PLANNING CONSULTATION RESPONSE

Application No	2025/1080
Proposal	Change of use of Working Men's Club (Use Class Sui Generis) to 9x supported living dwellinghouses for adults with staff facilities (Use Class C2) including associated alterations to the exterior of the building.
Address	2 Broad Street, Hoyland, Barnsley, S74 9DY
Date of Consultation Reply	19/01/2026
Consultee	Katie Lawrence, Planning Ecologist

Drawing Title
Existing & Proposed Ground Floor Layout Plans

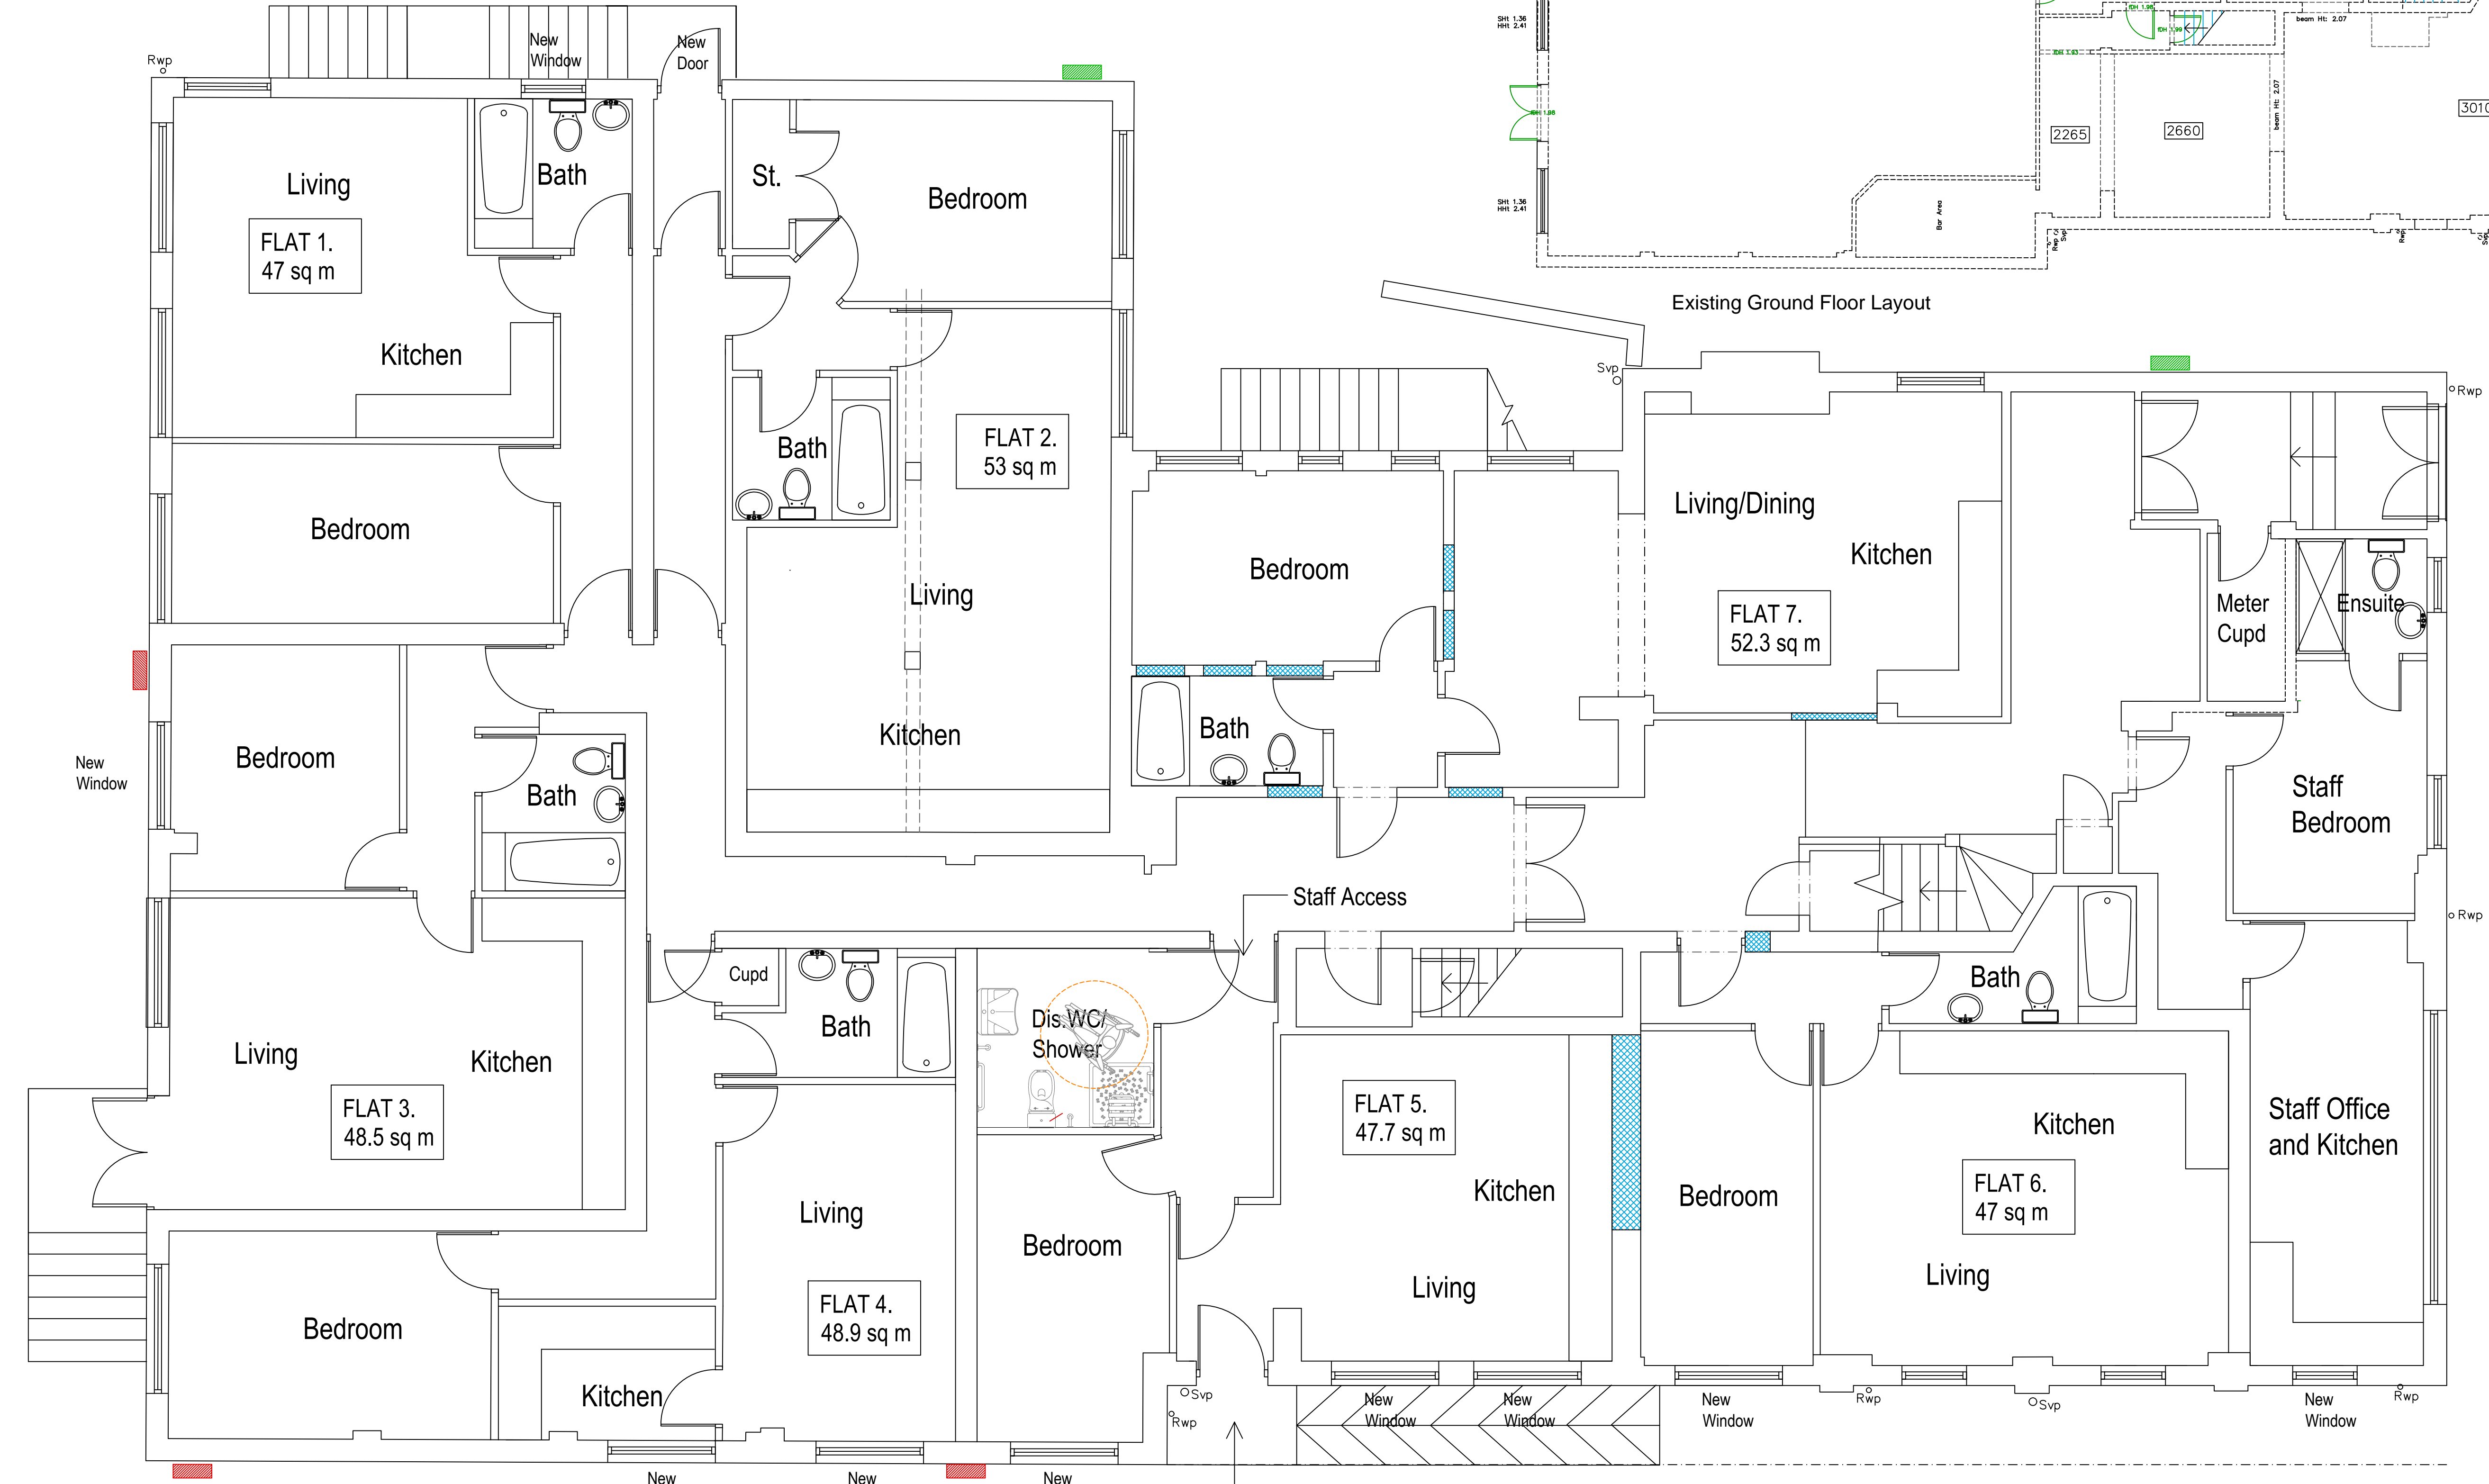
Thank you for consulting me regarding the above application. The development is exempt from Biodiversity Net Gain, meeting de minimis rules and due to the type of works proposed to the building the requirement for a preliminary roost assessment is considered unnecessary. In my pre-application response for these proposals (see separate attachment) I advised that the development should incorporate bat and bird boxes in the aim to enhance opportunities for biodiversity on site, as per the Biodiversity and Geodiversity SPD and National Planning Policy Framework. Can the applicant provide a plan showing types and locations of boxes proposed as part of the application, or this could be conditioned as part of the planning permission, if granted?
